**KIRKLEES METROPOLITAN COUNCIL
DEVELOPMENT & MASTER PLANNING SERVICE**

**DELEGATED DECISION FOR PRIOR APPROVAL FOR CHANGE OF USE
FROM – COMMERCIAL, BUSINESS AND SERVICE USES OR BETTING
OFFICE OR PAY DAY LOAN SHOP TO MIXED USE OF COMMERCIAL,
BUSINESS AND SERVICES USES AND AS UP TO 2 FLATS**

Reference no. 2025/CL/91485/E

**Prior approval for change of use
of first floor from commercial,
business and service to two
dwellings**

Block Plan 1:500

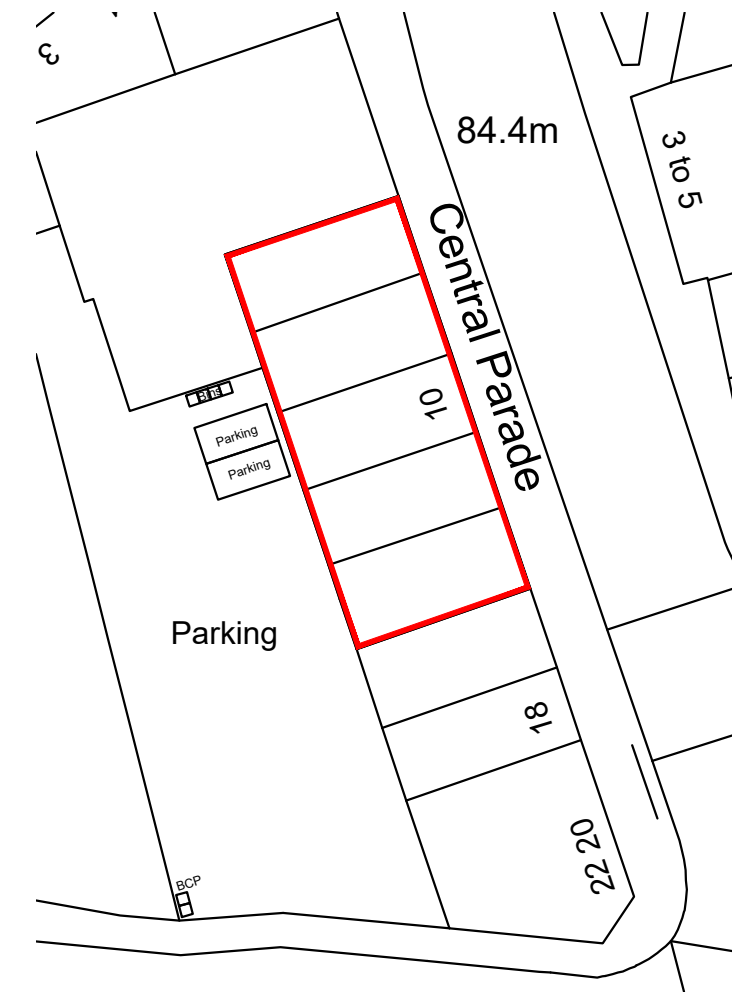
The proposal seeks prior notification for the change of use of an existing commercial building to two apartments, which would intensify the domestic use on site. A submitted block plan, shows that both flats will be served by one on site parking space each to the rear of the property which can be accessed off of Parkside. It is also noted that the site is located within a sustainable town centre within close proximity to transport infrastructure, it is considered acceptable in this instance.

Bin storage and collection points have been provided as shown on the proposed block plan and are considered acceptable.

As set out in the report, at the request of the case officer, a proposed block plan showing on-site parking spaces, and bin storage and collection point was submitted.

Client	
Project 6-14 Central Parade, Dewsbury Road, Cleckheaton	
Title Proposed Plans	
Scale 1:100 @ A3	Date
Drawn AC	Checked
Drawing No.	Rev. A

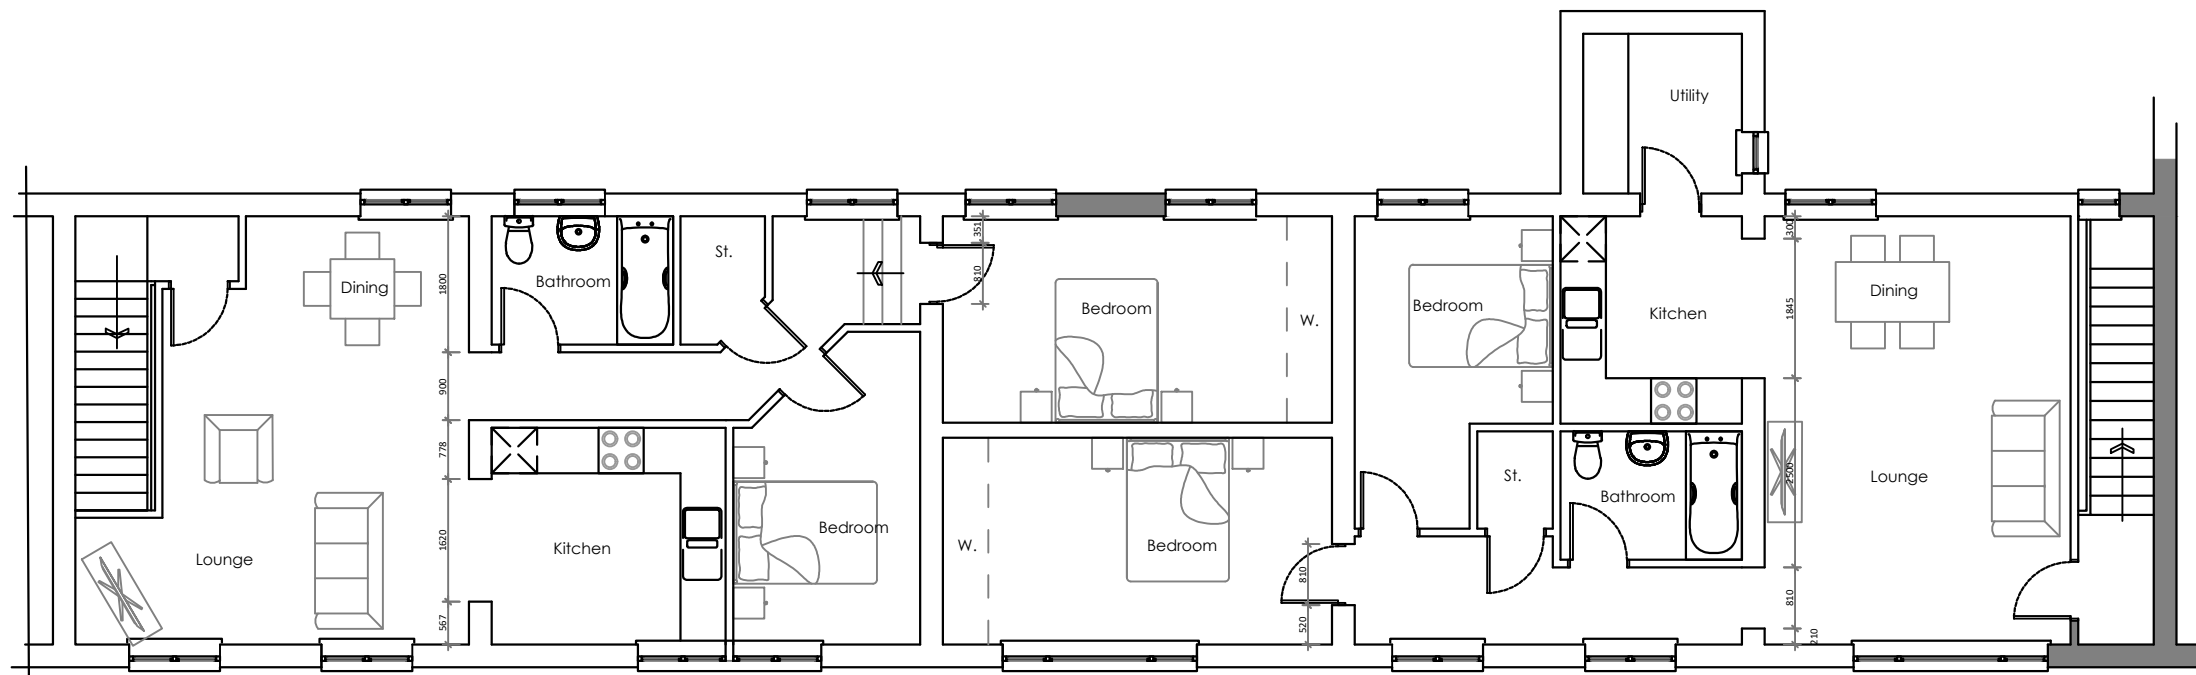
The flats will be accessed via the front elevation of the building. The submitted plans show space to fit a bike at ground floor. It is noted, however that the proposed plans indicates a physical alteration to the front of the building to replace a chamfered shop front with a flush frontage incorporating a new doorway to the proposed flats. While no elevational details have been provided, this is likely to constitute development requiring planning permission. However, the existing doorway could be utilised to create access to the first floor.

G1 (IV) requires the provision of adequate natural light to all habitable rooms of the dwellinghouse. Paragraph X of Part 3 defines habitable rooms and any rooms used or intended to be used for sleeping or living which are not solely used for cooking purposes.....". All rooms within the flats will be served by windows and as such all rooms will be served by adequate natural light.

The application has been submitted with insufficient information to allow the Local Authority to assess noise impacts although it is considered reasonable and necessary to require further details by condition. The plans also indicate the one bedroom does not benefit from any natural light and no details are provided relating to the location of bin storage.

NOTE: Development consisting of a change of use pursuant to Class G, Part 3 of Schedule 2 of the Town and Country Planning (General Permitted Development) (England) Order 2015 (as amended) does not permitted any external alterations which would materially affect the external appearance of the building. Any such alterations will require planning permission.
